Gatwick Northern Runway Project: Air Quality Written Representation Deadline 8

Client: CAGNE

Reference: APS_S1043A_A3-2

Date Published: 7 August 2024

Diagram 3.3.1: Model performance before and after adjustment, Generic zone

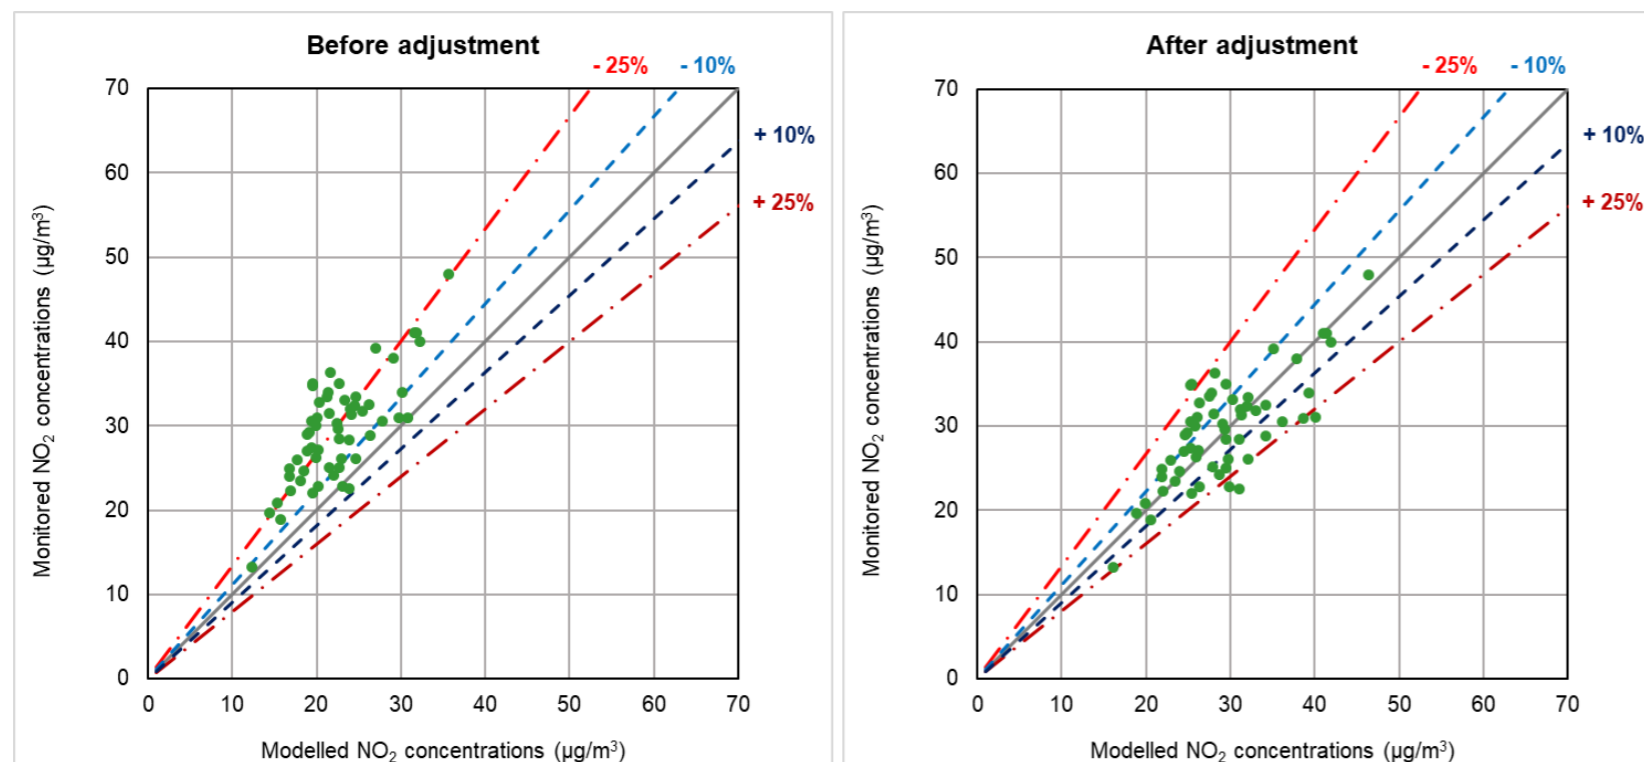
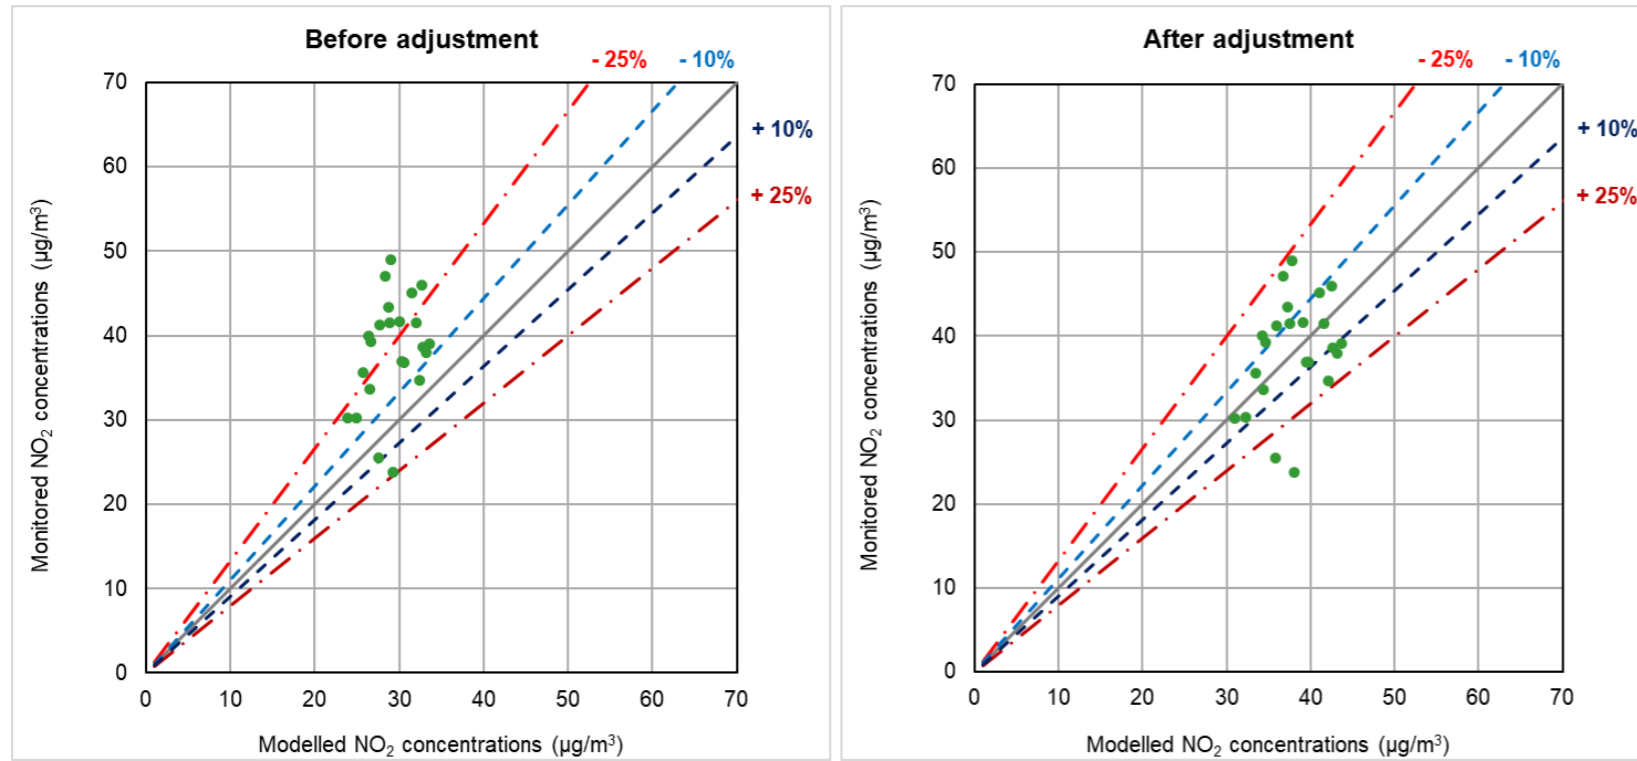
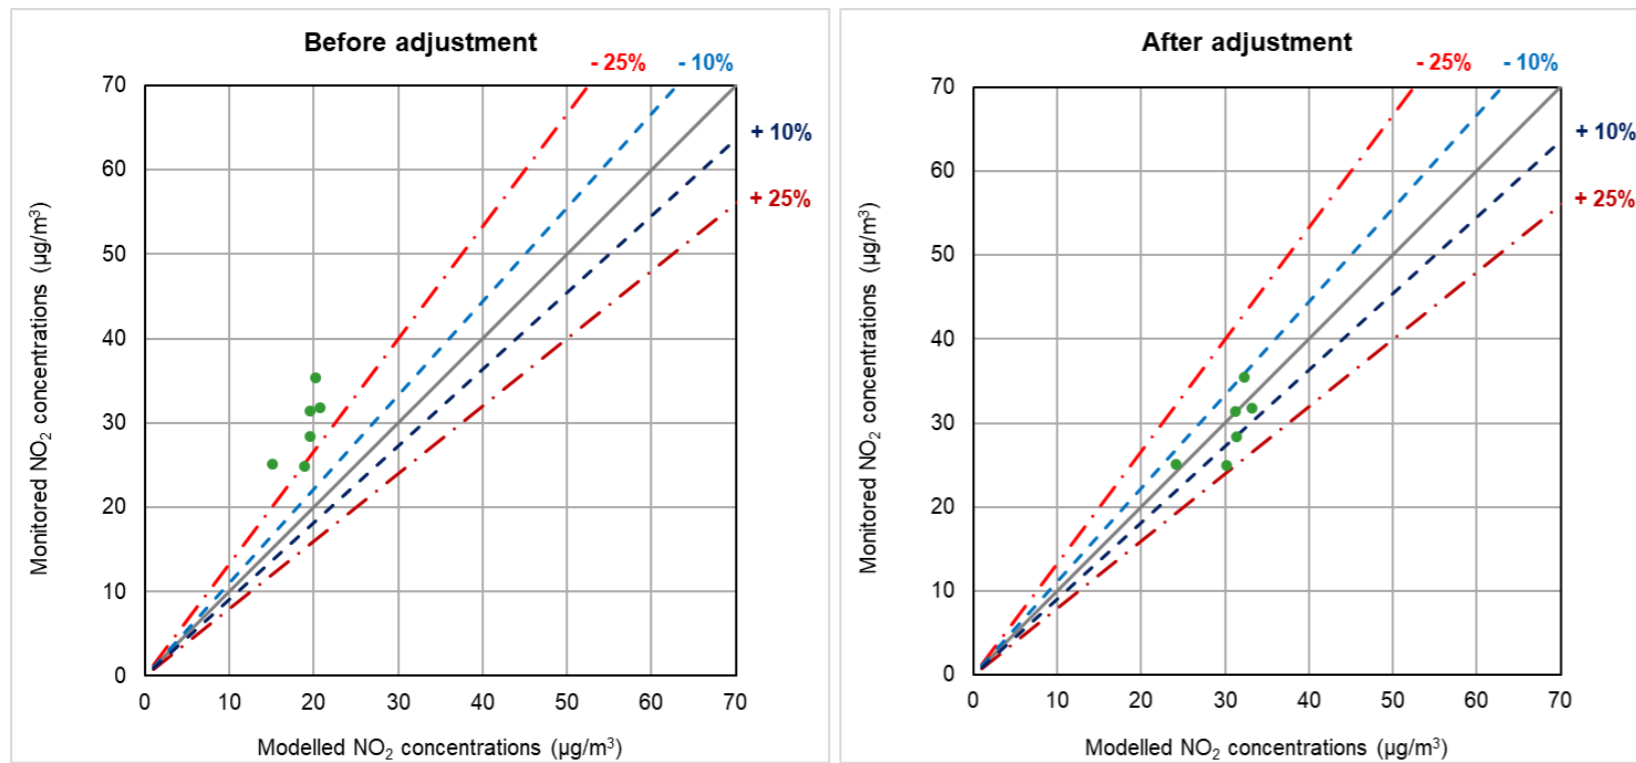
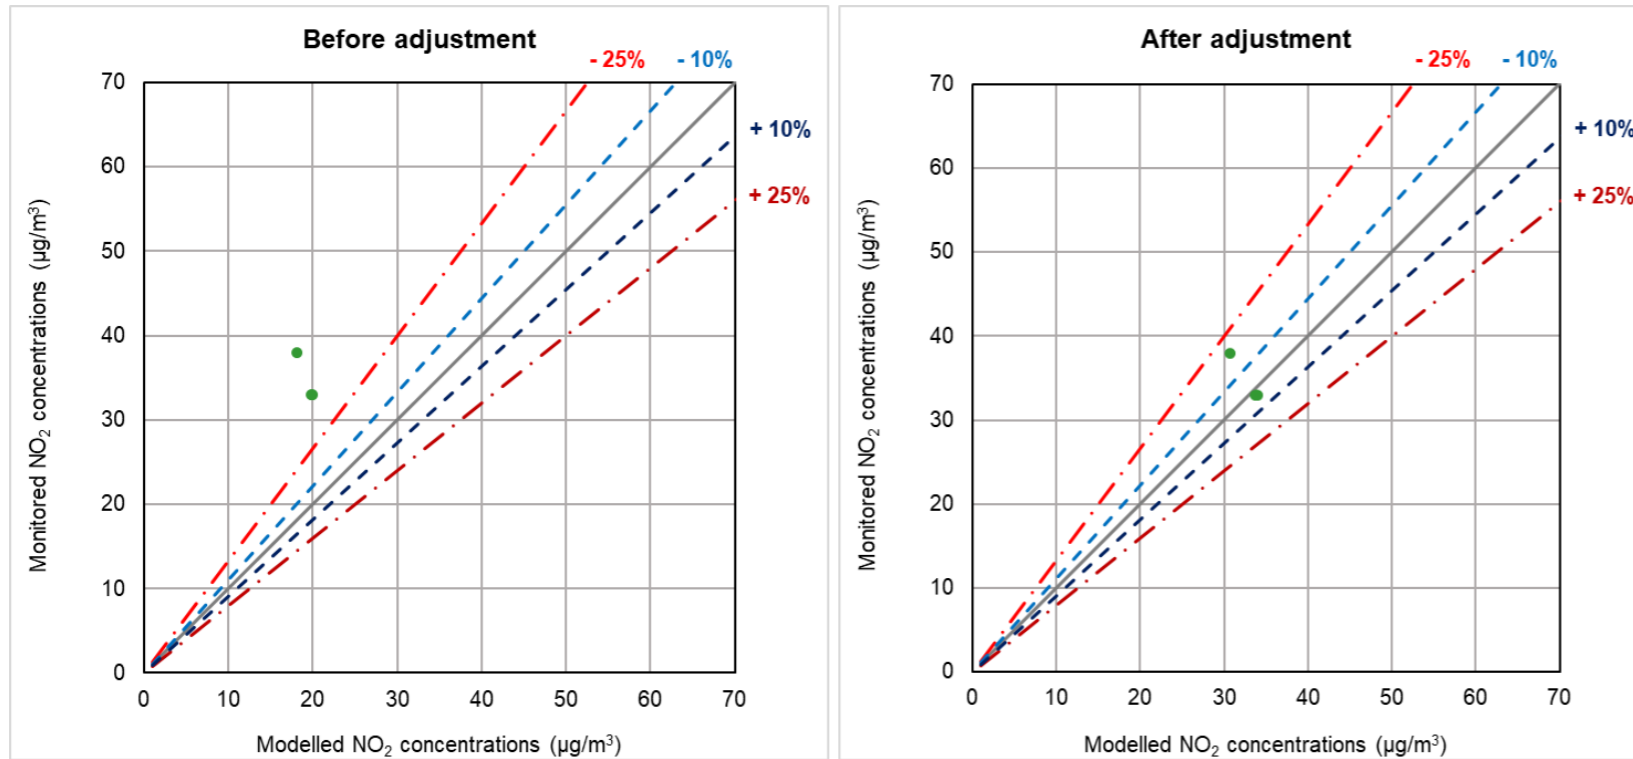
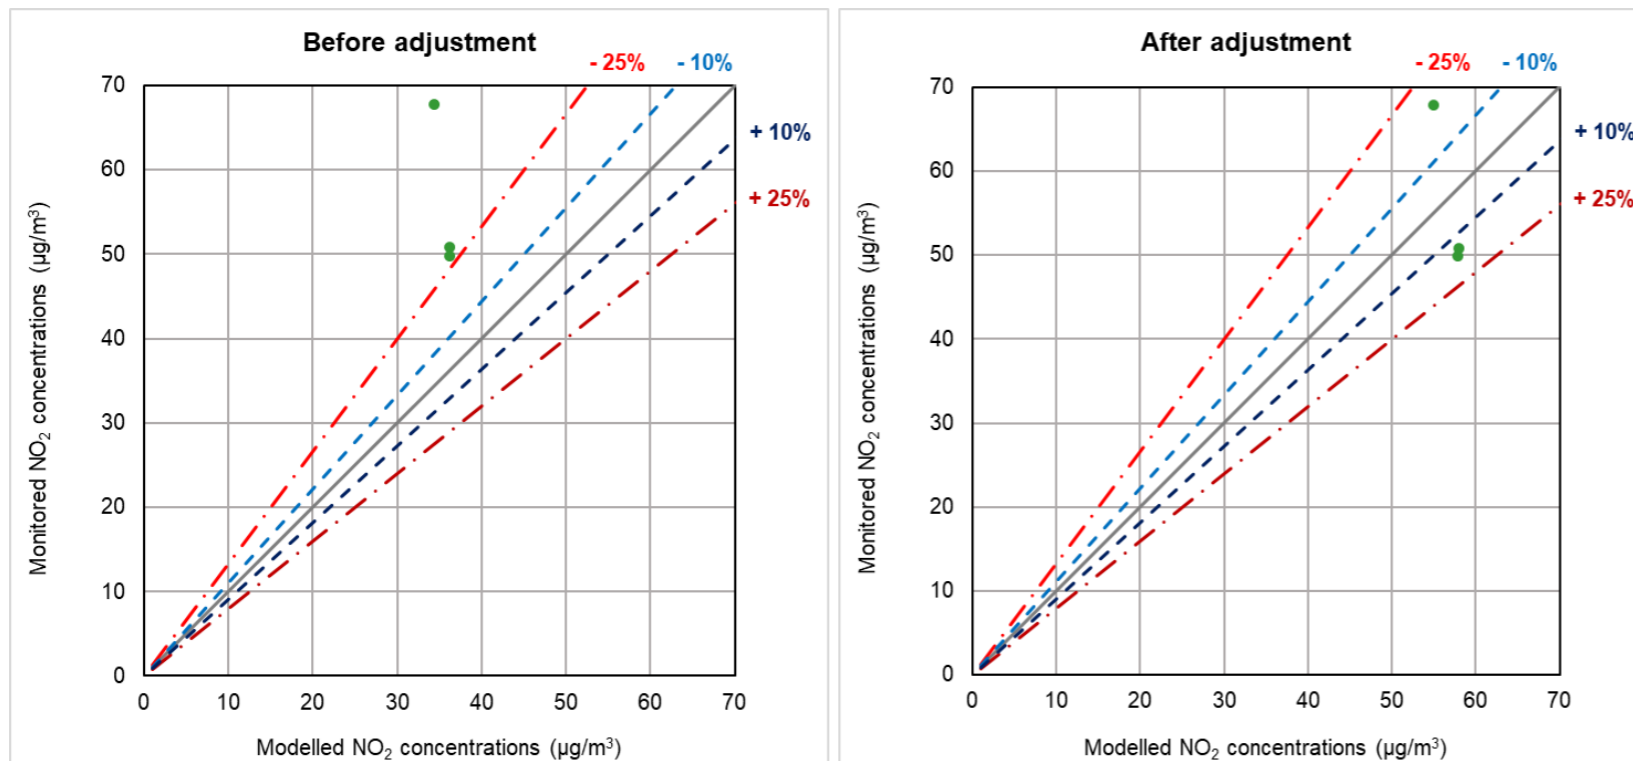
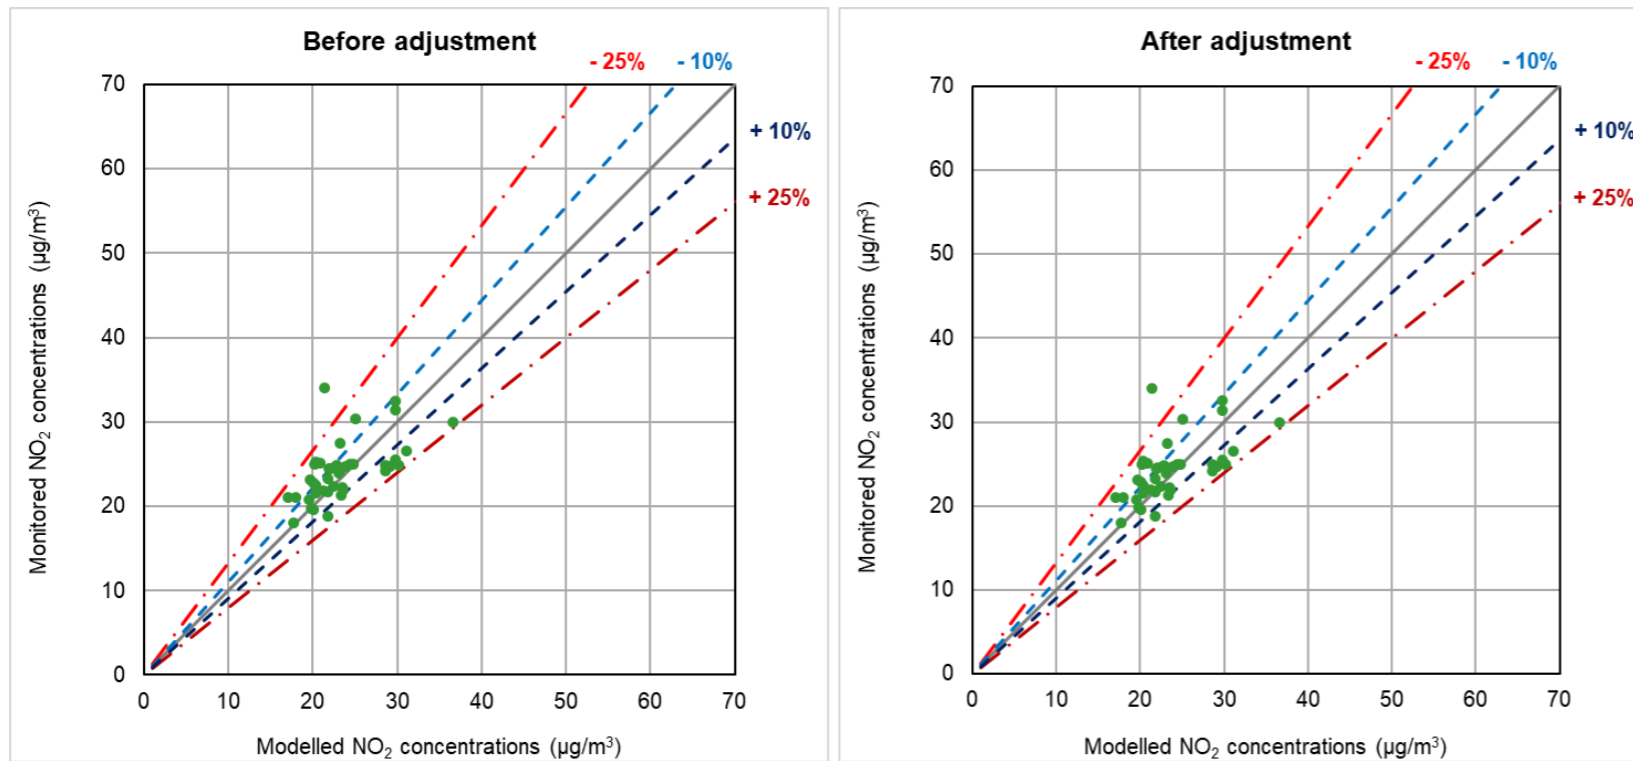
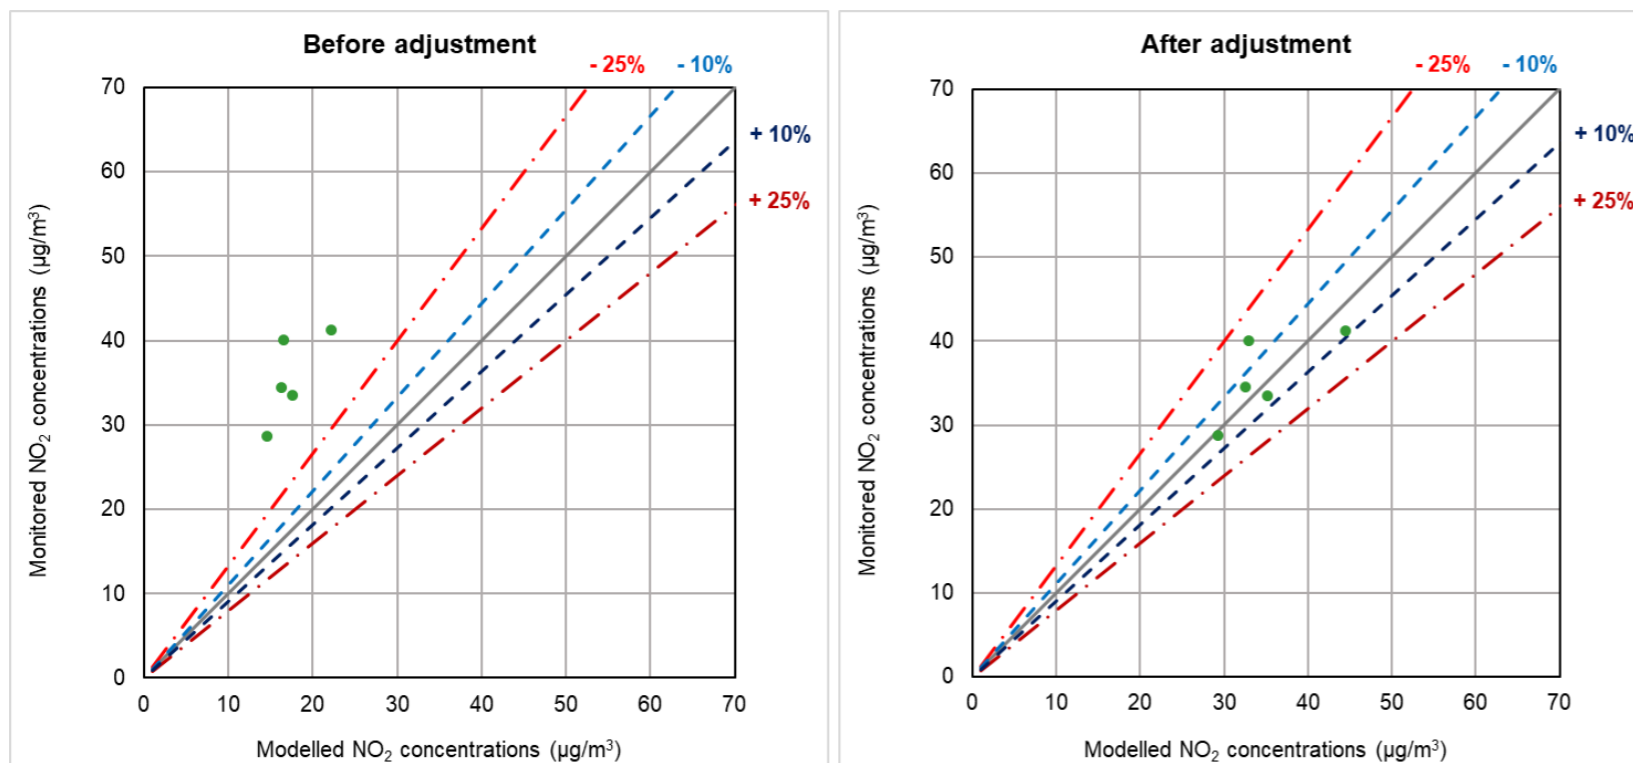
2.15. Section 5 of the GAL response provides a sensitivity test for the road transport emission model for 2032. Paragraph 5.2.14 states:

"The RMSE values are within $\pm 25\%$ of the objective being assessed. The annual mean objective for NO_2 is $40\mu\text{g}/\text{m}^3$, and the RMSE for all zones are lower than $10\mu\text{g}/\text{m}^3$, which is in line with the criteria outlined in section 7.585 of Defra's TG22."

2.17. These statements are incorrect because the paragraph in TG22 states (paragraph 7.585, APS emphasis):

"Ideally an RMSE within 10% of the air quality objective would be derived, which equates to $4\mu\text{g}/\text{m}^3$ for the annual average NO_2 objective."

2.18. Stating that the RMSE is within $\pm 25\%$ does not provide evidence that the model is performing well. It may be acceptable if the uncertainty is numerically taken into account during the assessment of the significance of the predicting effects, which is not the case.

2.19. Paragraph 5.2.7 of the GAL response states regarding the sensitivity test undertaken:

"It shows that the use of one factor across the whole study area would reduce the accuracy of the results compared with the approach used in the ES assessment. This is demonstrated by the number of sites that are within $\pm 25\%$ after adjustment, as well as the statistical parameters used to evaluate model performance."

2.20. In fact, what both the single adjustment and the zonal adjustment factors demonstrate is that at locations where there is no monitoring (i.e. the modelled receptors), there is large uncertainty in the predicted concentrations. As the Applicant is unable to provide individual justification for each zonal adjustment factor (i.e. there is no explanation of why the adjustment factor should be different in each zone; the ES only quotes generic reasons for differences) it is not possible to determine whether that approach is better or worse for predicting concentrations at the receptors than the use of a generic adjustment factor. What is worrying is that the model using the zonal adjustment factors failed to estimate concentrations at the monitoring sites within 10% of the measured concentration at over half the monitoring sites. The application of a zonal adjustment factor to a particular receptor is not justified and there are many examples of close receptors allocated to different zones for no apparent reasons (see Figures 20 to 36 in *Gatwick Northern Runway Project: Air Quality Written Representation Deadline 4*). This is lack of specific justification for the zones adopted s unacceptable.
